Re: **Sunnyside Village Cohousing – PA 22-042 – Concurrency Recommendation**

The applicant is proposing the development of a 32-unit cottage housing community with a shared use common house on roughly 4.75 acres, located at 3121 66<sup>th</sup> Ave NE and further identified by APN(s): 29050300402100.

### 66TH AVE TYPICAL SECTION

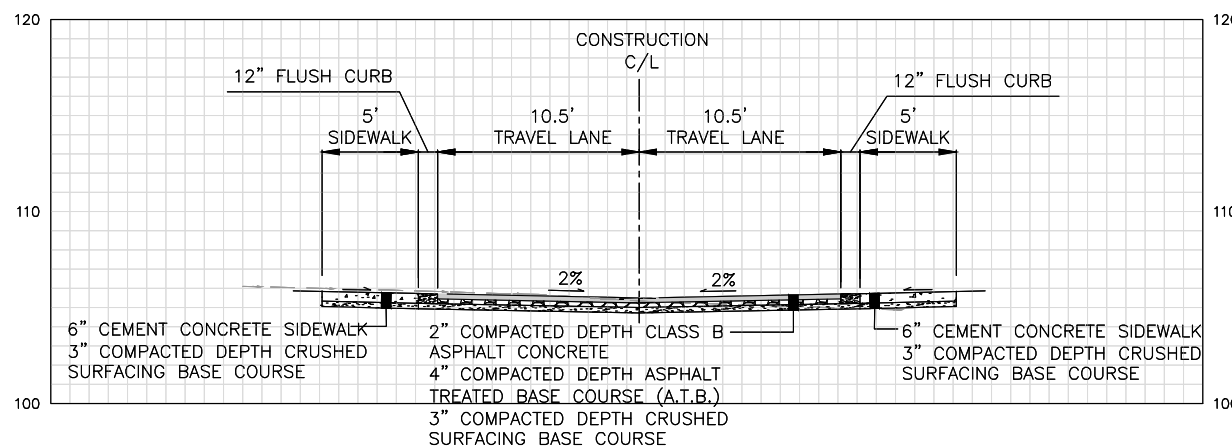
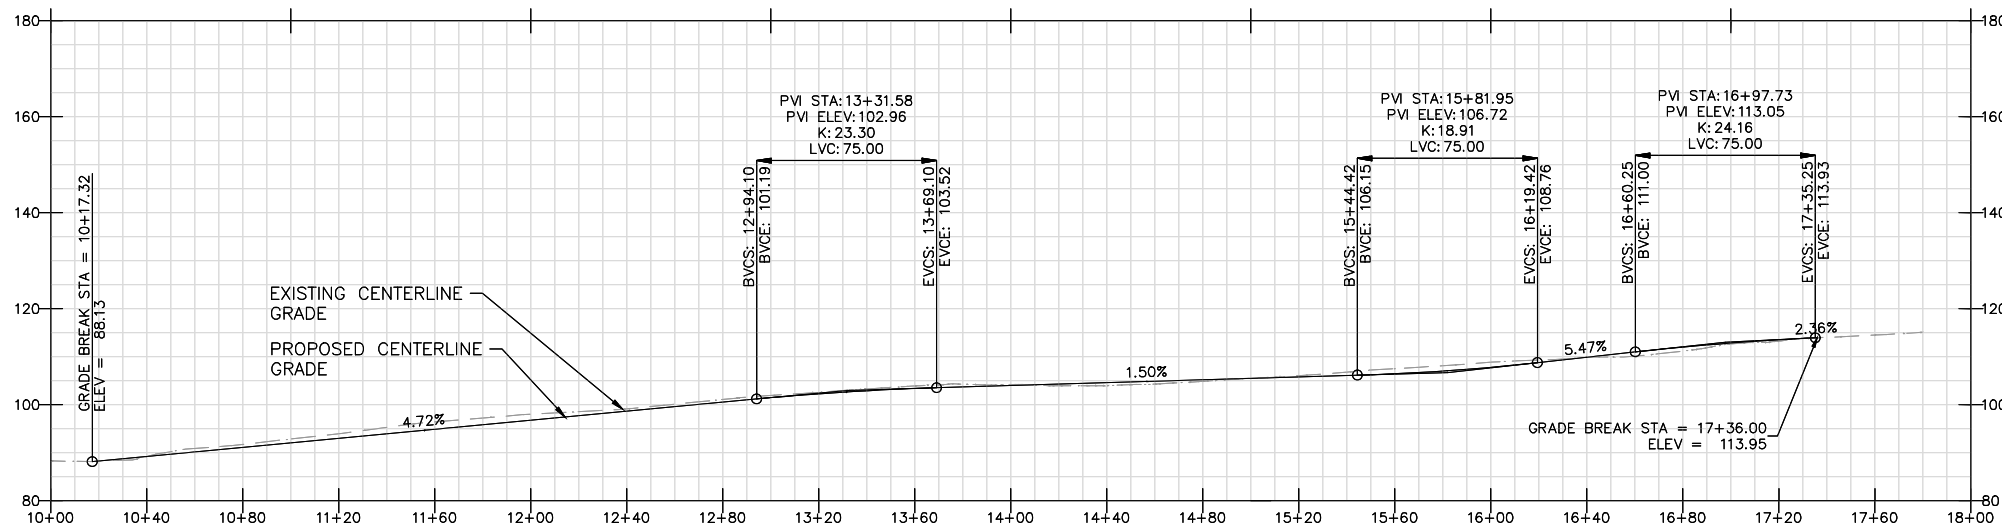
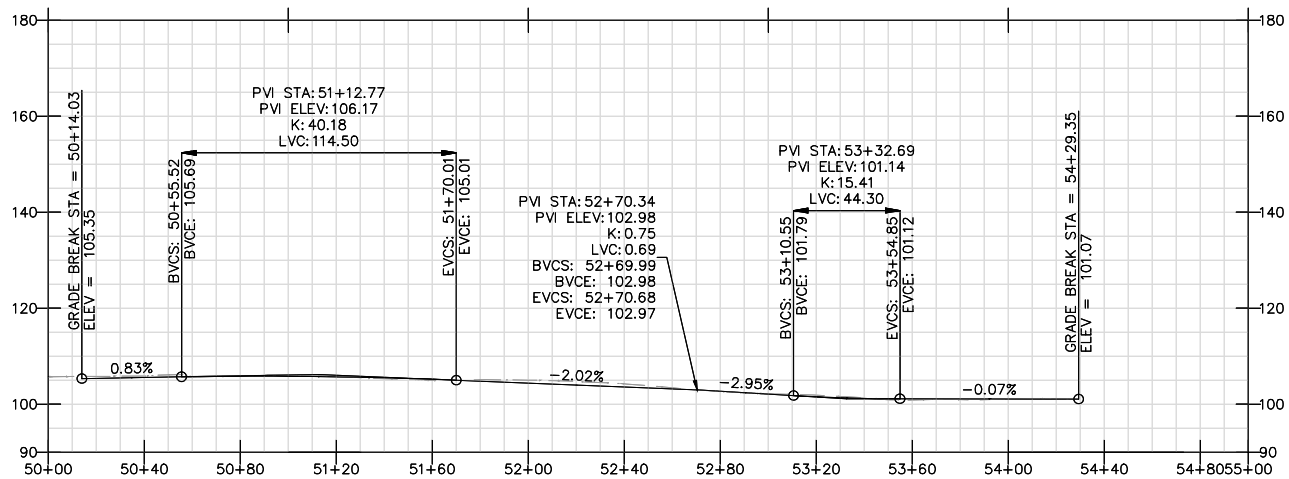
1. The applicant shall be required to construct frontage improvements along 66<sup>th</sup> Ave NE, prior to final plat approval. Roadway improvements, channelization, site access and lighting plans shall be required to be reviewed and approved by the City Engineer, prior to construction plan approval.

- 1.1. 66th Ave NE is classified as a local access street and is to be built compliant with SP 3-202-002 of the EDDS.
2. The applicant shall be required to dedicate public right-of-way for the extension of 66<sup>th</sup> Ave NE in accordance with MMC 12.02A.110(1)(c), *Dedication of Road right-of-way – Required setbacks*. Right-of-way widths and required dedication shall be determined by the City Engineer.

- 2.1. The extension of 66th Ave. NE requires a 50 ft. dedication, which is currently shown on the supplied documents.
3. In order to mitigate impacts upon the future capacity of the road system, the applicant shall be required to submit payment to the City of Marysville, on a proportionate share cost of the future capacity improvements as set forth in MMC 22D.030.070(3), for the development. **Traffic impact fees shall be vested at a rate of \$6,300.00, per PMPHT, totaling \$195,300.**

The design team has reviewed and accepts the requirements outlined in the concurrency recommendation document.
